DRB Application No.: 10DRB-70308

Project # 1008484

Project Name: *Ocate Elementary School*

10DRB-70238 VACATION OF PUBLIC EASEMENT

**SKETCH PLAT AND VACATION REQUEST
TRACT A, ONATE ELEMENTARY SCHOOL**

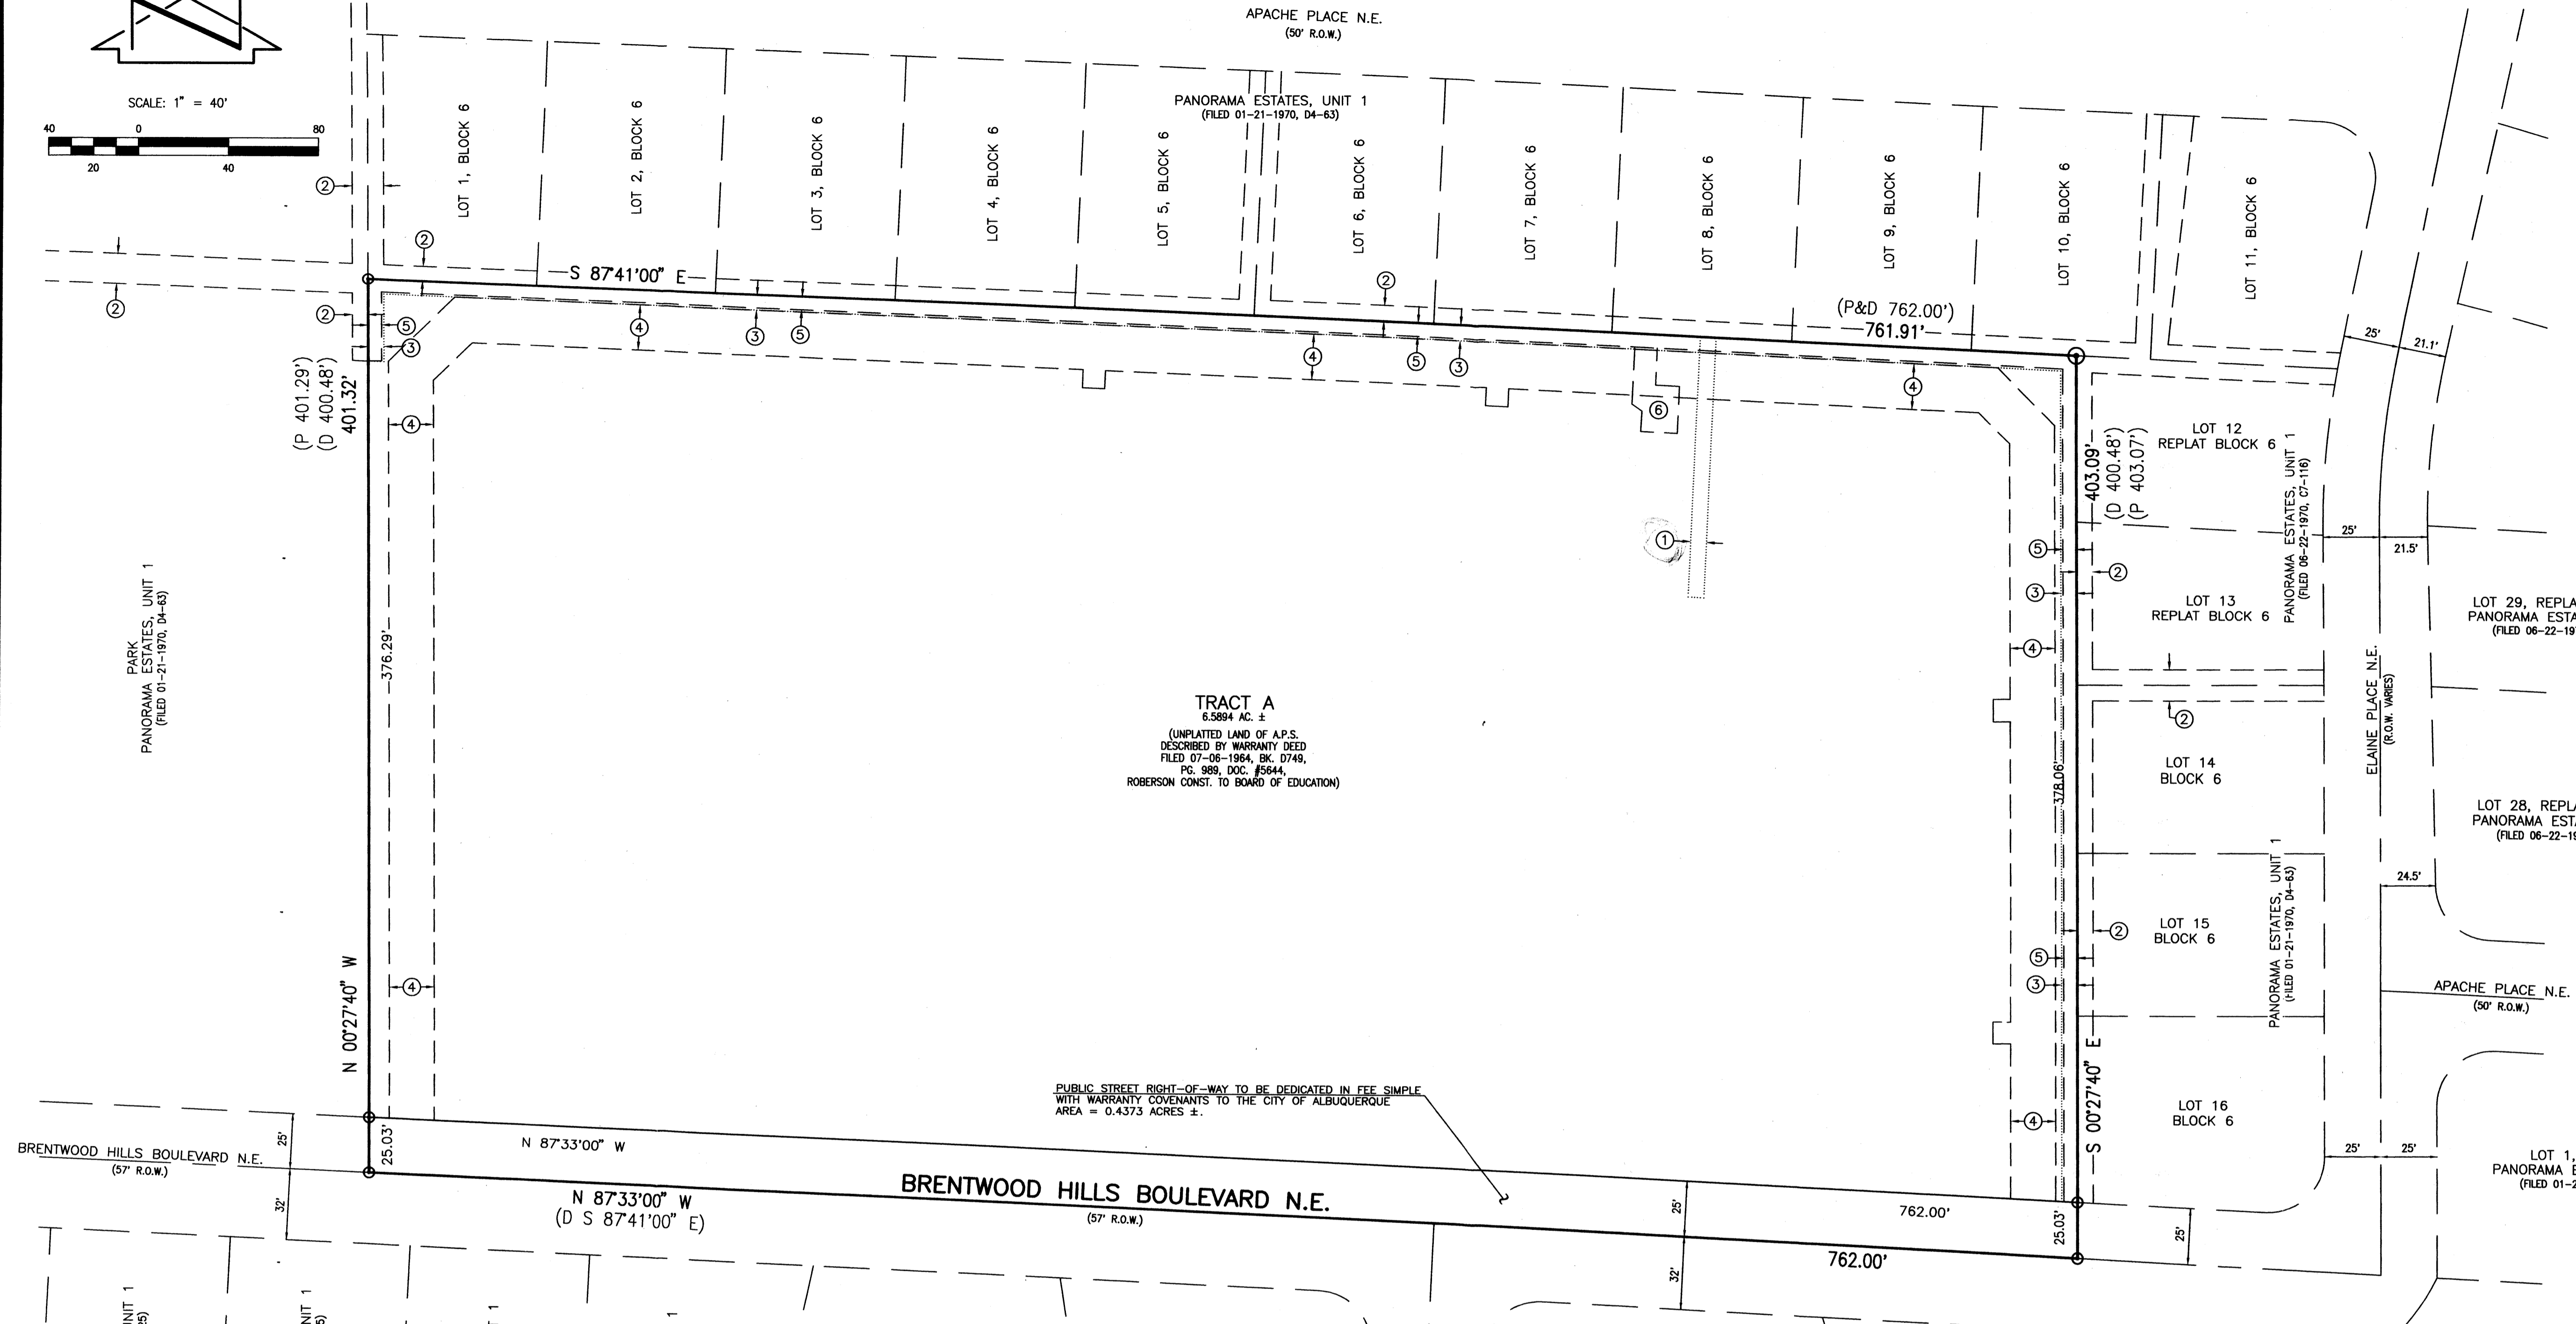
Provide an exhibit showing the location of sidewalk and defining the distance from face of curb to the proposed property line. Additional right of way dedication may be required.
